RE: REVISED DRAINAGE PLAN FOR PROPOSED OFFICE & WAREHOUSE @  
LOT 9 RICHFIELD PARK (C17-D2A13) REVISION DATED 6/24/96.

RE: CONCEPTUAL GRADING & DRAINAGE PLAN FOR PROPOSED OFFICE  
& WAREHOUSE (C17-D2A13) ENGINEER'S STAMP DATED 2/4/96

**CONCEPTUAL  
GRADING & DRAINAGE PLAN**

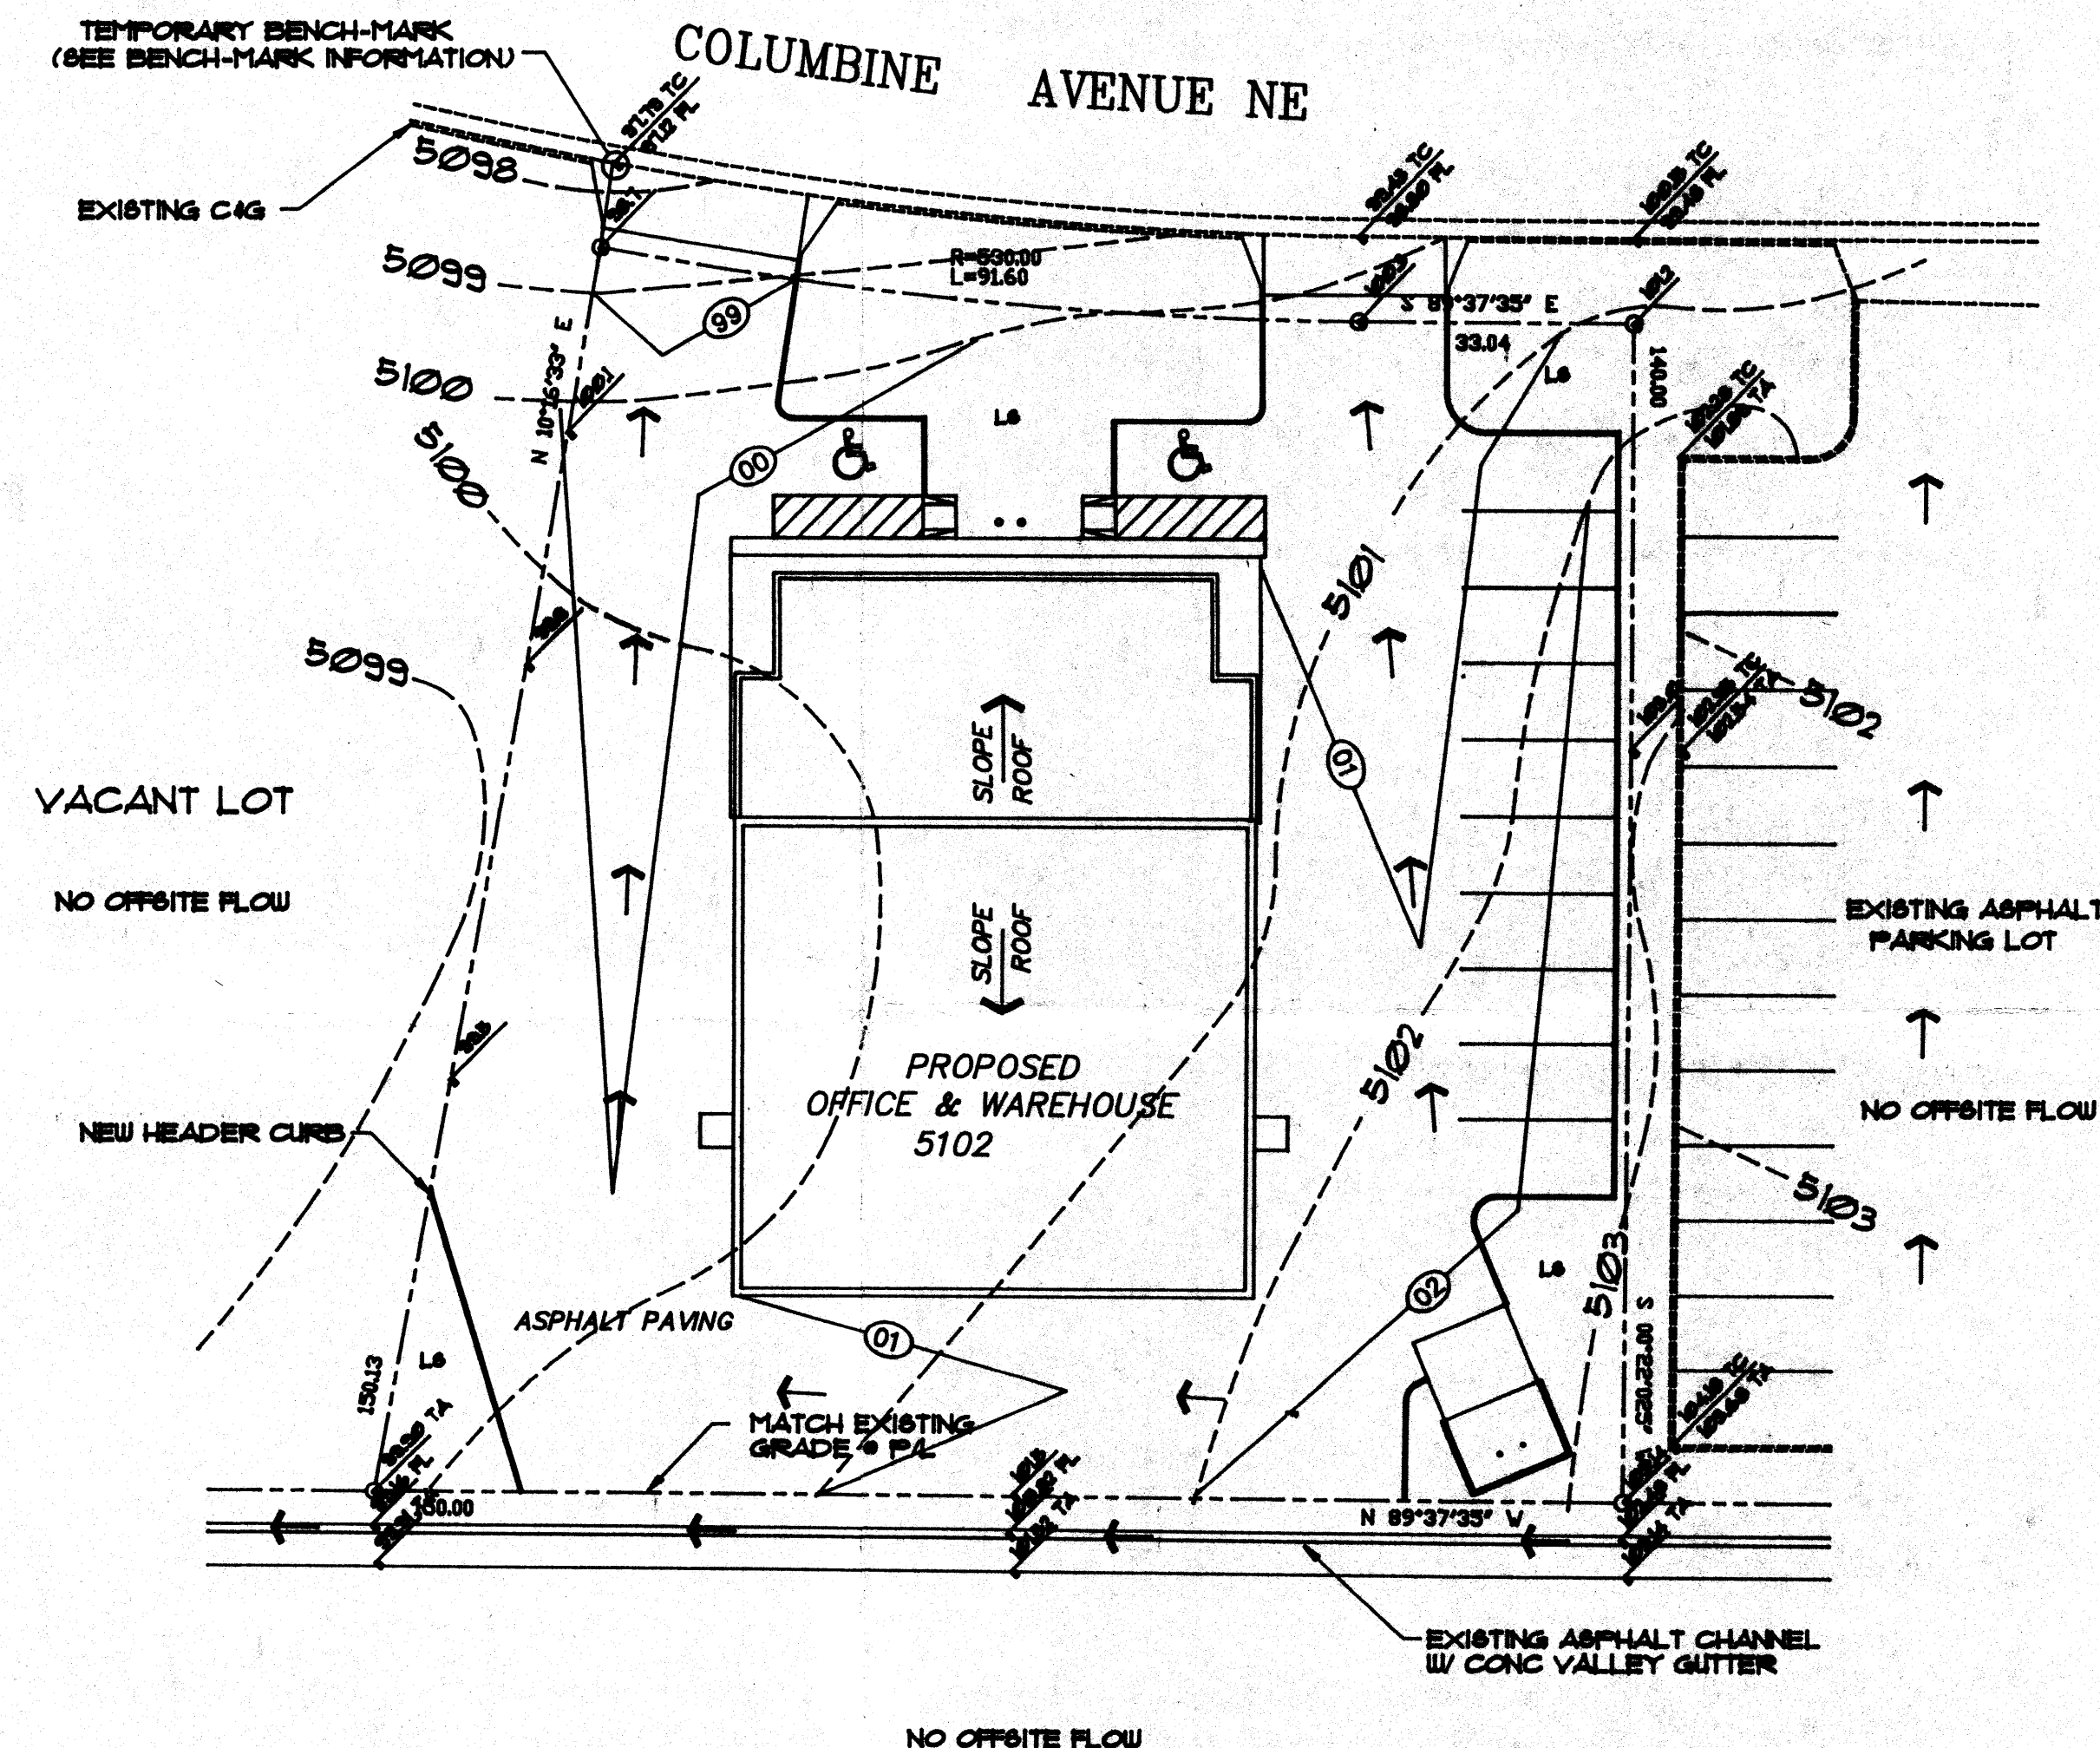
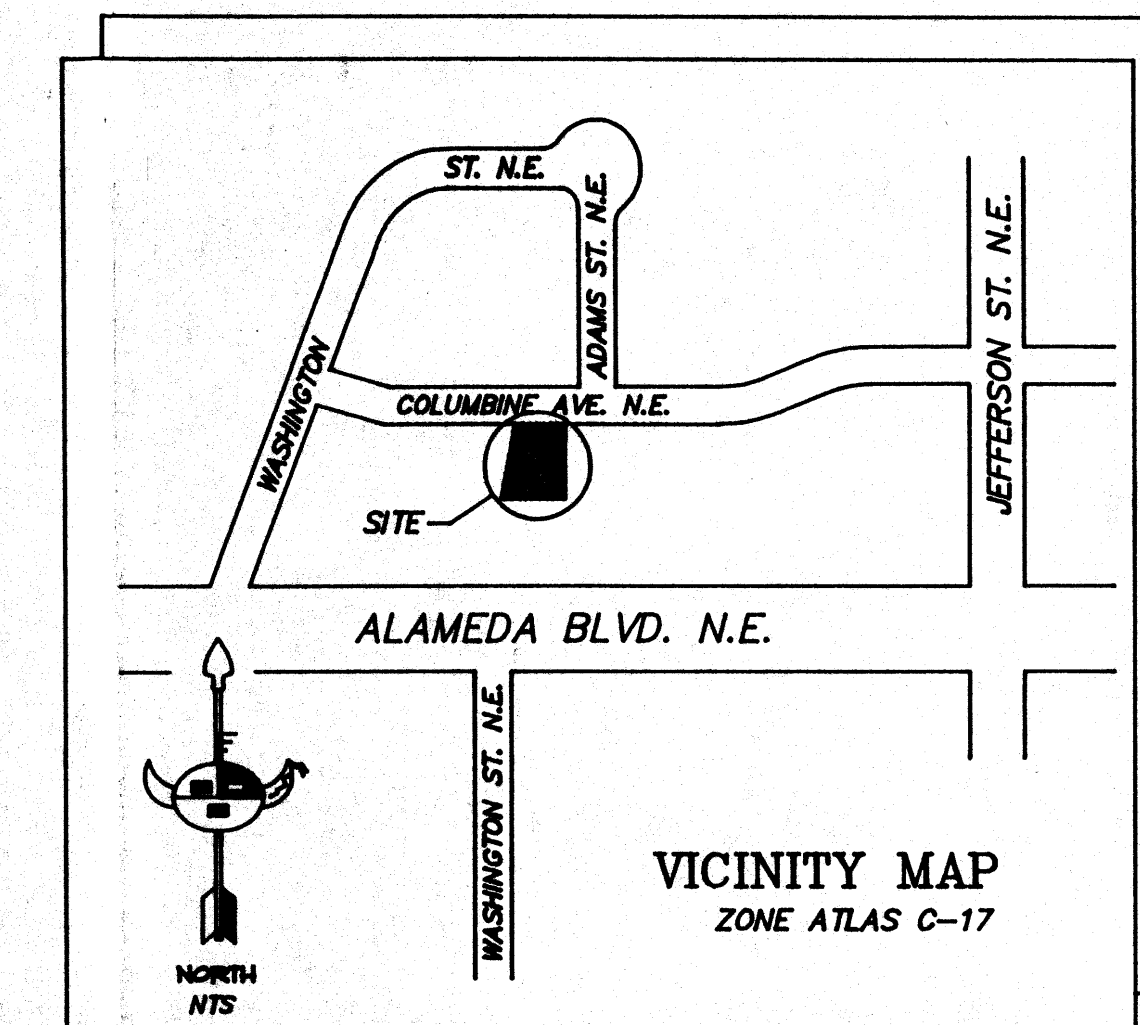
1. T.B.M. must be permanently marked.
2. Indicate the slope of the proposed swales on the plan drawing.
3. Roof run off must be routed away from the landscape areas.
4. Propose that you extend the header curb all along the west property line.
5. Quantification of flow rates and volumes.
